Sent: 14 October 2013 11:37
To: Planning
Subject: Welwyn Hatfield Council Online Planning - Comment

Application Number: S6/2013/1916/FP
Name: Sarah Horwood
Address: Beaumont Oak, Beaumont Road,
Broxbourne, EN10 7QJ
Comment Type: Object

Figure 1 – Proposed External Works

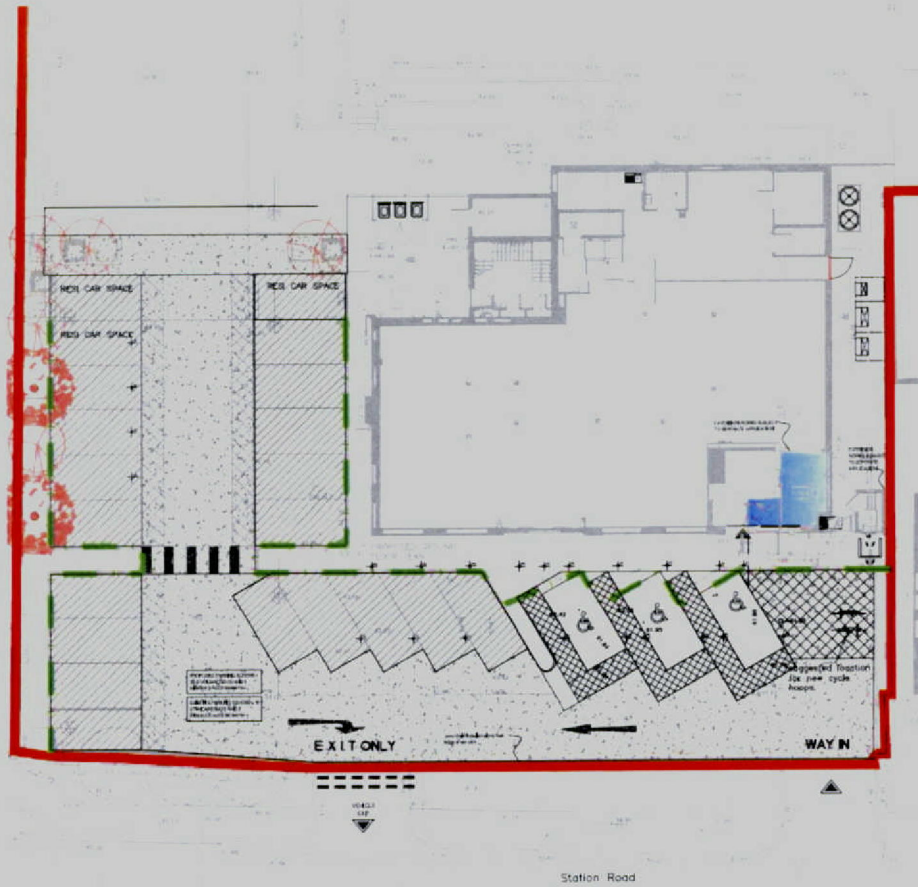
Comment: I am the leaseholder of the 3 flats above the Tesco store in Cuffley. Under the terms of my lease there are FOUR parking spaces allocated to these flats. One each for Flats 1 and 2, and 2 for Flat 3. In this application only 3 are mentioned....therefore this wording needs to be changed. I also gather that the planned cycle hoops are to be placed on the footpath leading up to the gated entrance to the flats. I object to this as the path will be blocked by the hoops and any bikes parked there.
